**Re: Forest Lodge Integrated Seniors Living (SSD-75493483) – Response to Submissions**

In accordance with the Department’s Request for Additional Information dated 2 October 2025, this letter is provided to address the key issues and comments raised by the Department, City of Sydney and the agency advice received in response to the Environmental Impact Statement for SSD-75493483.

PROJECT No. **S24129** DRAWING No. **CI-0201** REV **D**

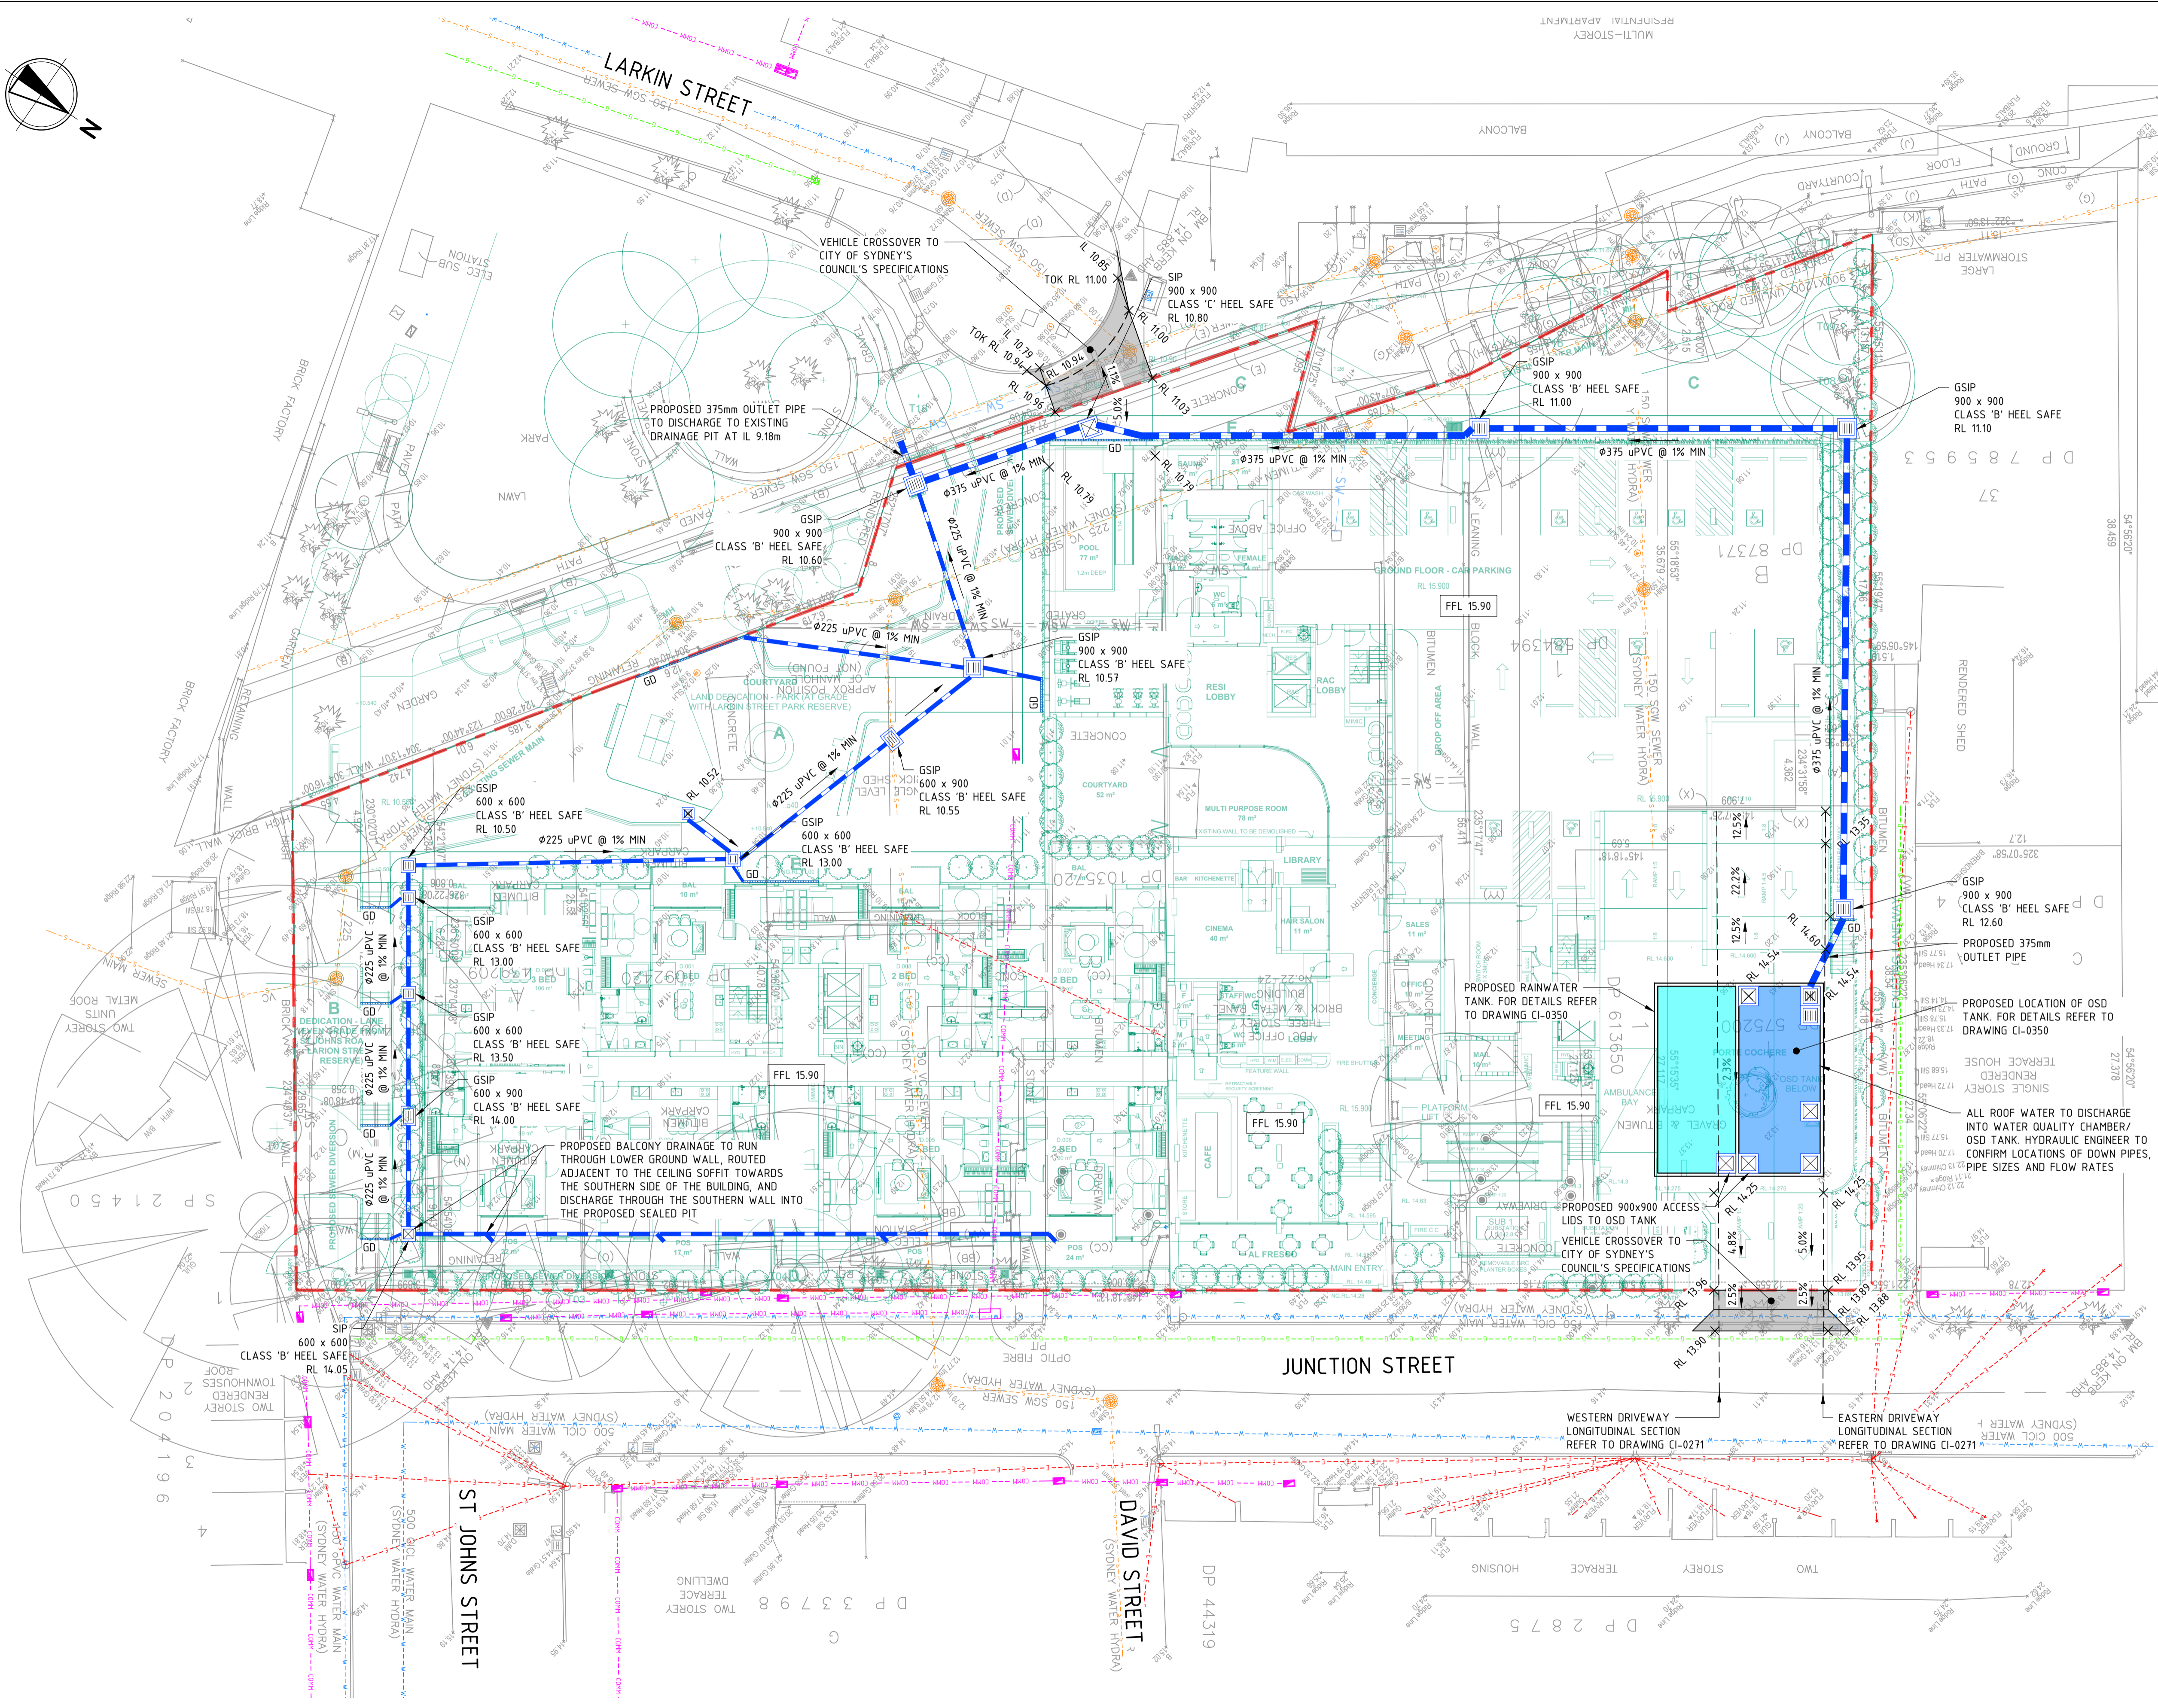
<b>Stormwater Plan</b>	<p><i>Issue: The stormwater plans show proposed stormwater infrastructure along the western boundary that appears to extend beyond the site boundary. Please clarify the arrangement for any proposed works outside the boundary and provide the landowners consent where required. Alternately, the plans may need to be amended to ensure all works are contained within the site.</i></p> <p><b>Response:</b></p> <p>The stormwater plans do not propose any drainage infrastructure outside the site. Please refer to the updated Plans S24129-DRG-CI-0200 and CI-0201-D which show all drainage contained within the site.</p>
<b>Stormwater Plan</b>	<p><i>Issue: There are discrepancies between the levels and stormwater pits, with one pit level at R.L 13.00 draining upstream into another pit with an invert level of 10.50. Please review the stormwater plan and confirm all levels are correct.</i></p> <p><b>Response:</b></p> <p>Please refer to the updated drawing S24129-DRG-CI-0201 which now shows the correct grate level referencing.</p>
